415 Cumberland Avenue (corner of Forest Ave) - Driveway Cross-slope

Keith Gray <kgray@portlandmaine.gov>

Fri, Apr 20, 2018 at 3:04 PM

Sheet Title:	<b>SITE PLAN</b>
--------------	------------------

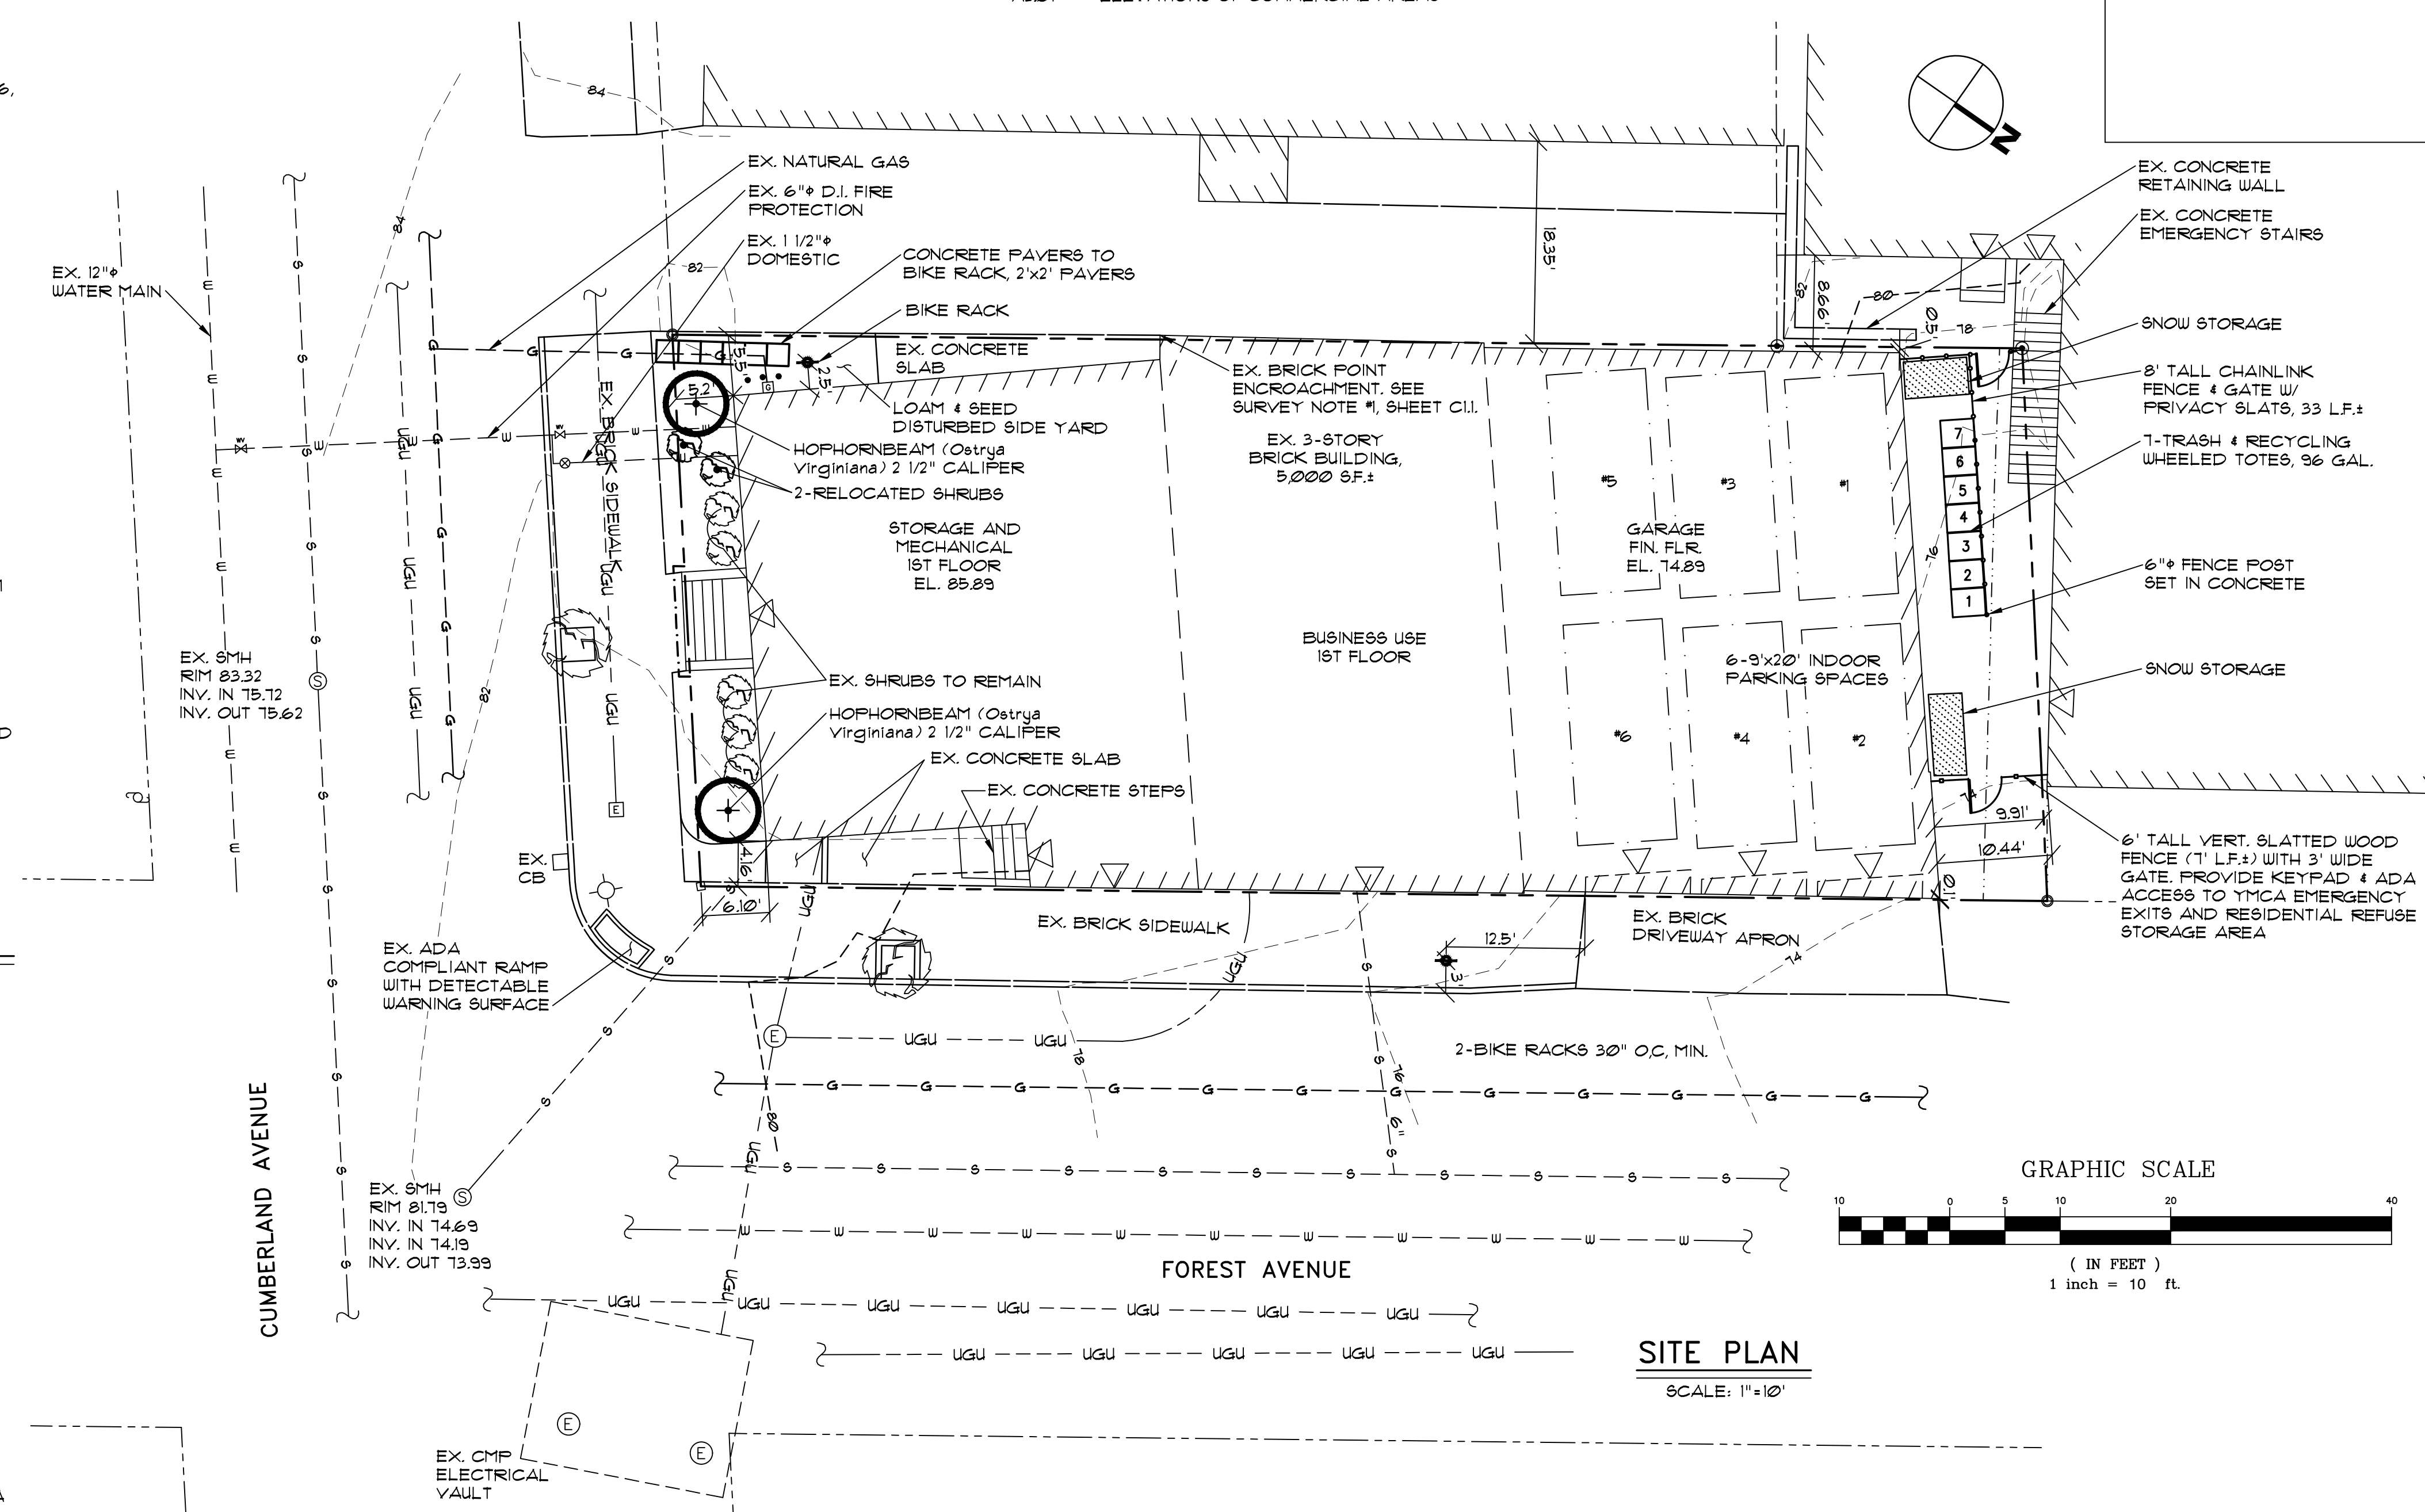
DPW position is that the driveway apron shall be reconstructed in conformance with technical standards. That being said, the apron should match into the existing sidewalk conditions which appear to be in excess of 2 percent cross slope. We do not want a case where the apron is 2% matching into 4-10% grades creating an even steeper grade. We would require existing and proposed grades for analysis.
